MORGAN AND MORECAMBE OFFSHORE WIND FARMS: TRANSMISSION ASSETS

Works Plans - Onshore and Offshore

Deadline: Deadline 6
PINS Reference: EN020028

Document reference: B7/F05
Rev: F05

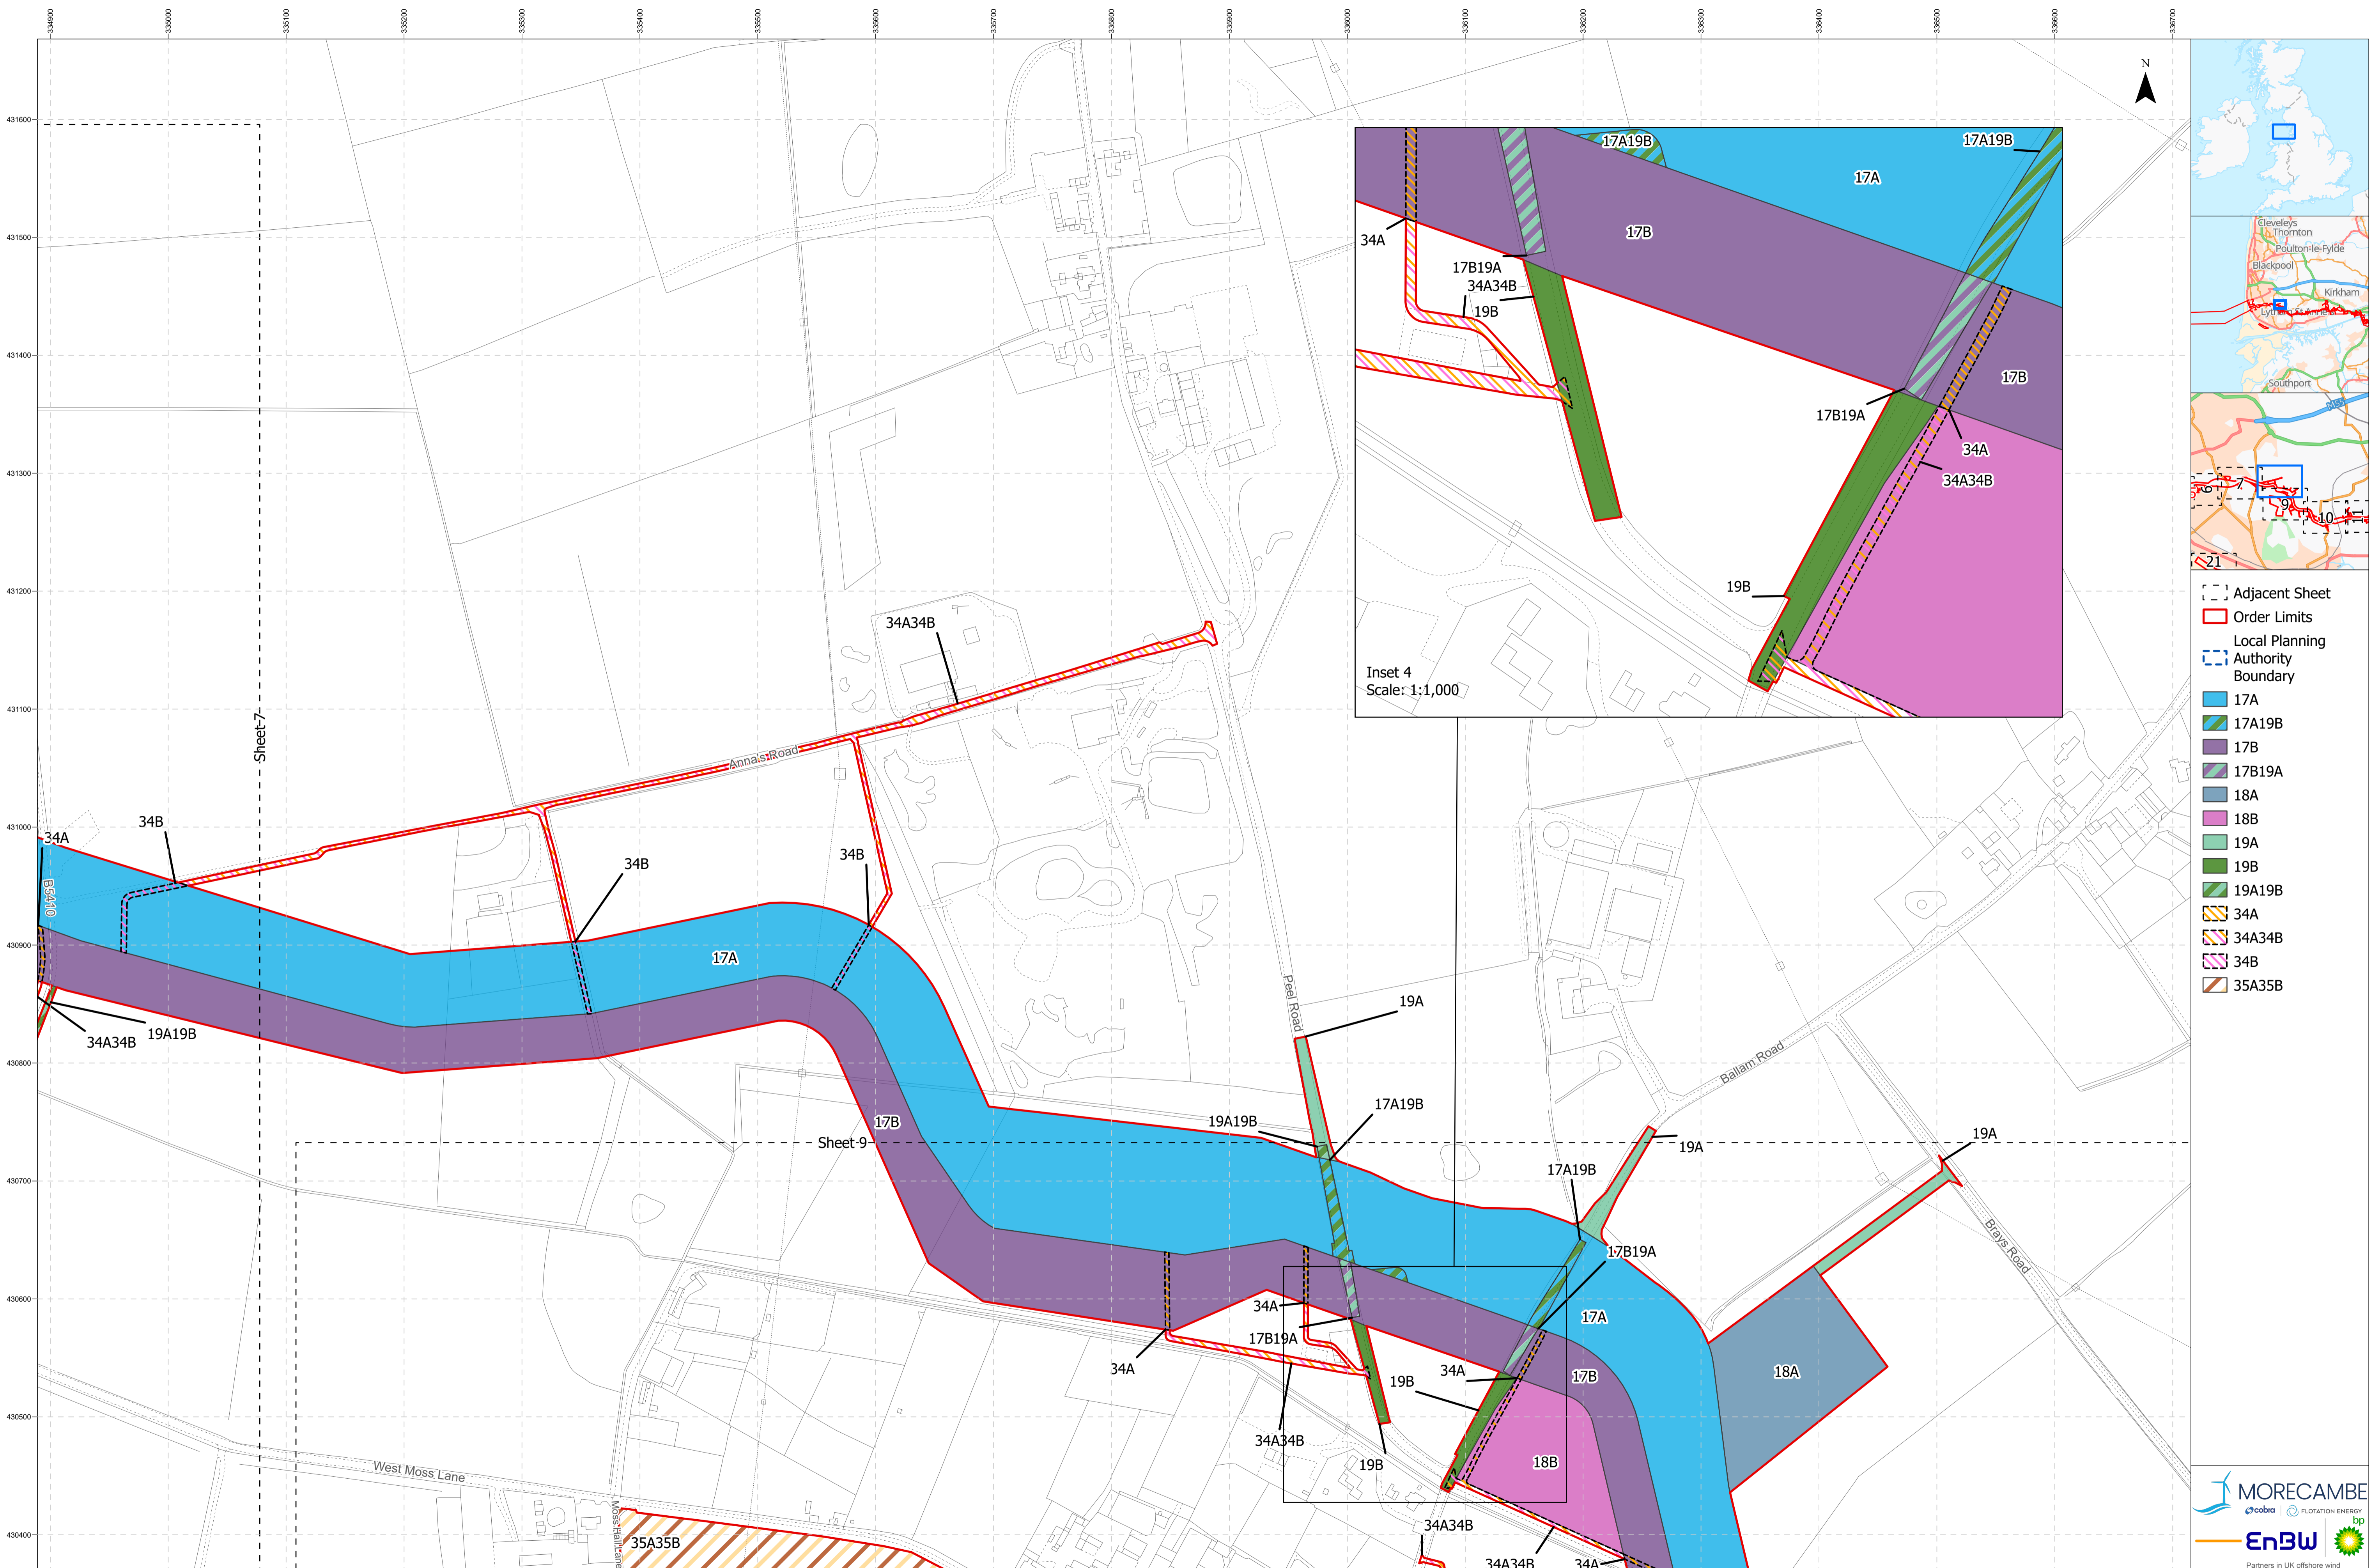
Sheet Number	Change requested by	Change Made	Reason for Change	Revision	Submission deadline
7	The Applicants	Permanent access (Work No. 34A) has been extended, near to Moss Sluice watercourse.	A review of the works plans identified that permanent access (Work No. 34A) to Morgan's onshore export cable corridor (Work No. 17A) was previously omitted. This has now been updated to reflect the Morgan permanent access (Work No. 34A) to cable corridor (Work No. 17A)	F02	S51 advice update
7	The Applicants	The permanent access (Work No. 34A34B) to both Morecambe and Morgan's onshore cable works (Work No. 17A and 17B) has been refined west of Midgeland Road.	A review of the works plans identified that permanent access (Work No. 34A) did not need to extend over Morgan's onshore export cable corridor (Work No. 17A). Similarly, permanent access (Work No. 34B) did not need to extend over Morecambe's onshore export cable corridor (Work No. 17B).	F02	S51 advice update

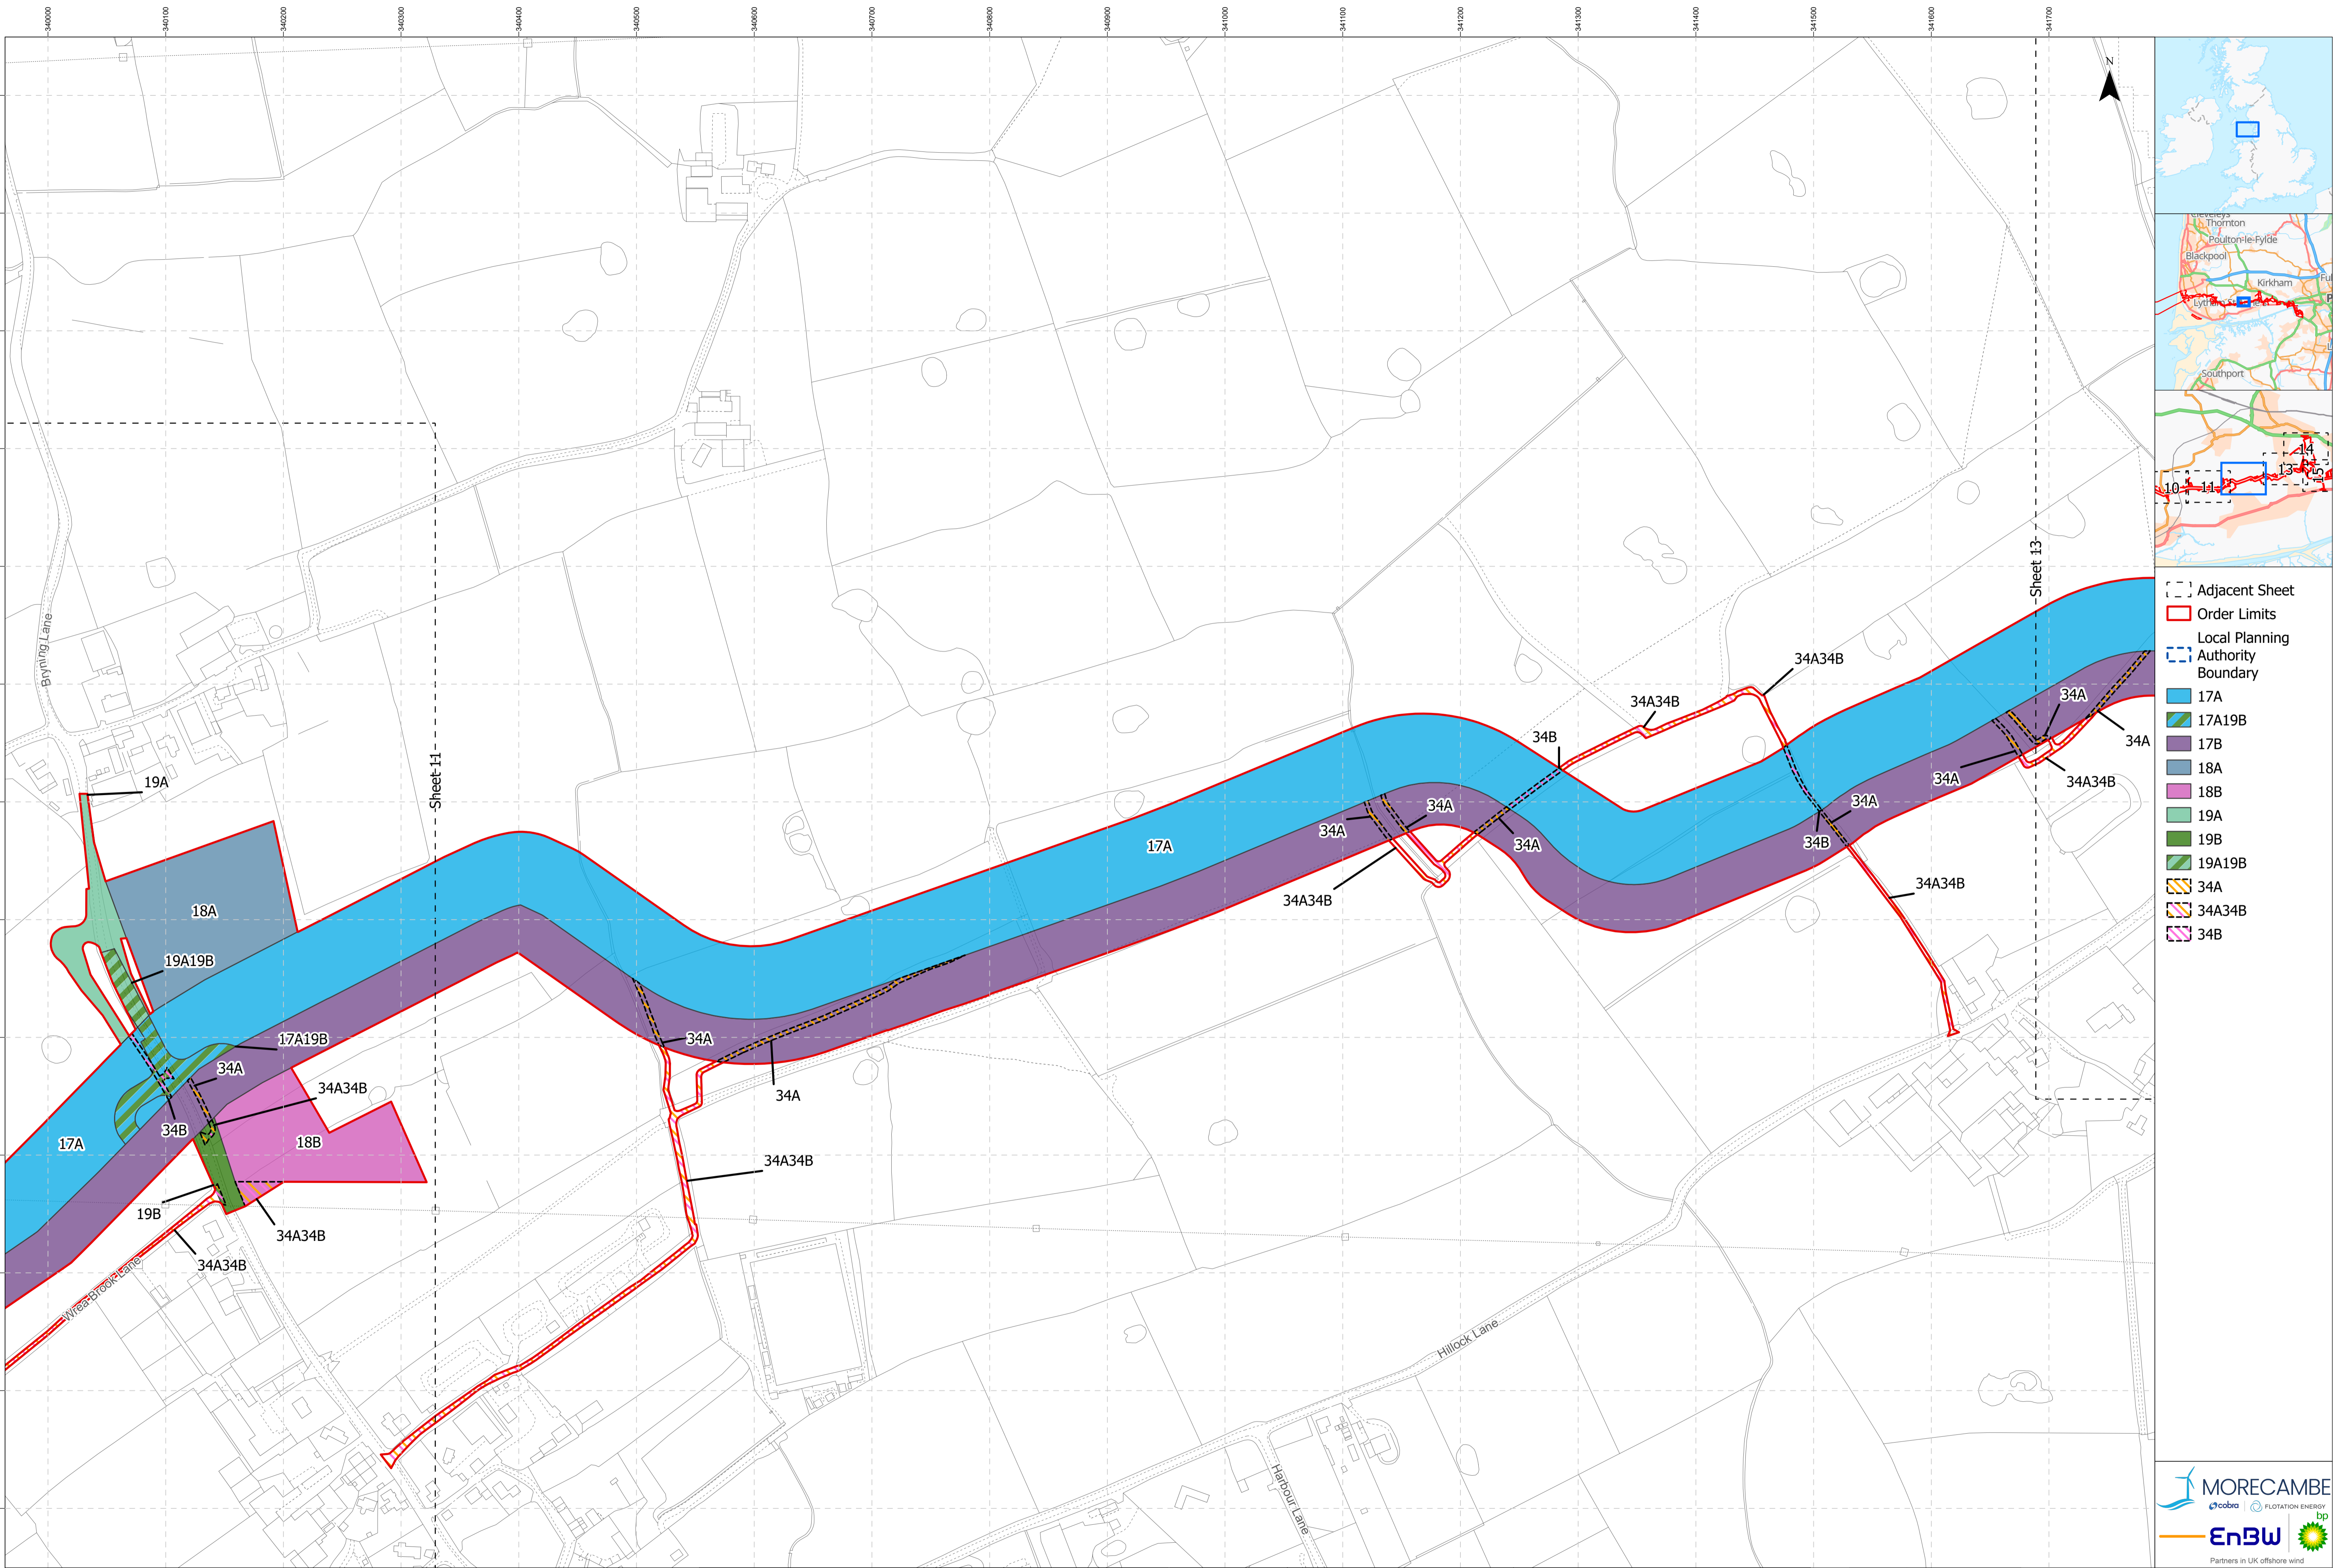
10	The Applicants	Construction access to environmental mitigation works (Work No. 40A40B) has been removed, south of Cartmell Lane.	A review of the works plans identified that construction access to environmental mitigation works (Work No. 40A40B) was not required at this location.	F02	S51 advice update
11	The Applicants	Morgan construction and permanent access to environmental mitigation works (Work No. 40A41A) has been remove off Cartmell Lane.	A review of the works plans identified that construction and permanent access to environmental mitigation works (Work No. 40A41A) was not required at this location.	F02	S51 advice update
11	The Applicants	Permanent access (Work No. 34A34B) off Wrea Brook Lane has been removed.	A review of the works plans identified that permanent access (Work No. 34A34B) was not required at this location.	F02	S51 advice update
